**STATE SIGNIFICANT DEVELOPMENT APPLICATION SSD – 8950984
BURRENDONG WIND FARM – PROPOSED WIND FARM WITH UP TO 70
WIND TURBINES AND ASSOCIATED INFRASTRUCTURE**

This document is a submission by way of objection to SSD 8950984 (the State Significant Development Application) relating to the proposed Burrendong Windfarm (located on the subject site).

D.5 U8-1 Dwelling Assessment

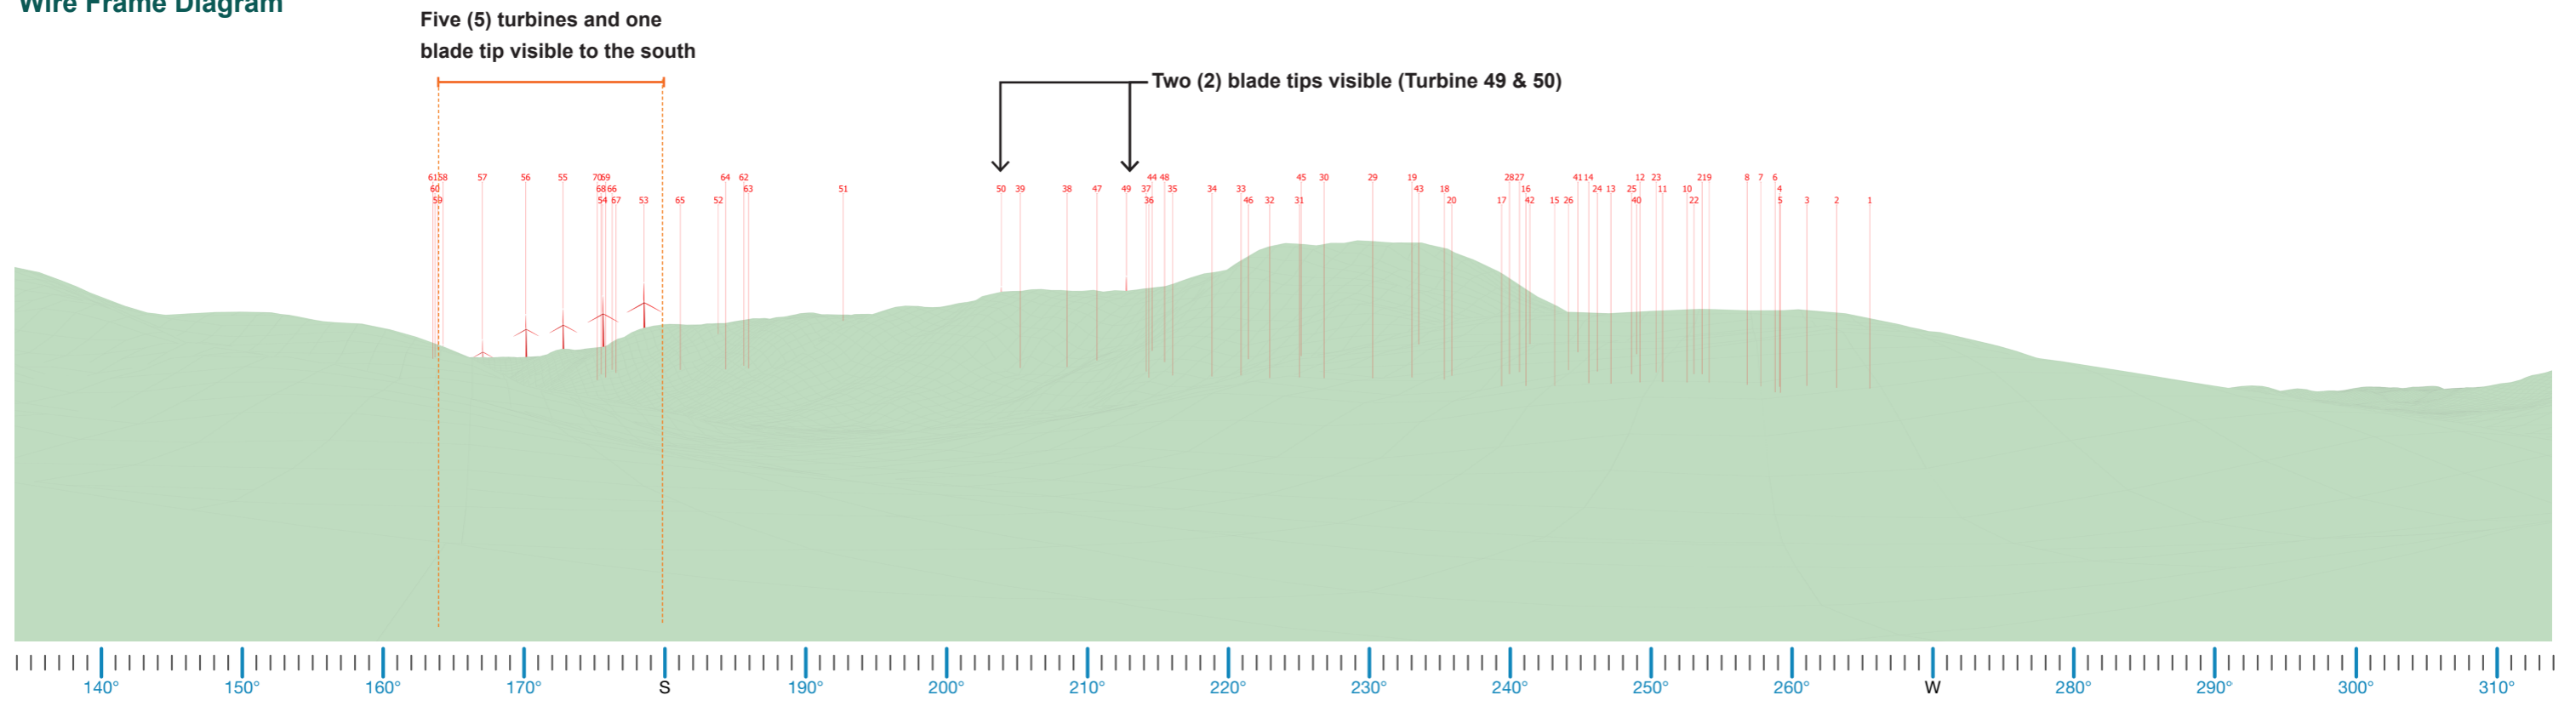
The photomontage under depicts the typical visual impact of the development in relatively close proximity to the Worlds End Ridgeline, Worlds End, in terms of our clients representatives property.

Figure 1: Photomontage from Client Representatives Dwelling U8-1 looking south-west towards Worlds End Ridgeline - Produced by Epuron dated March 2022
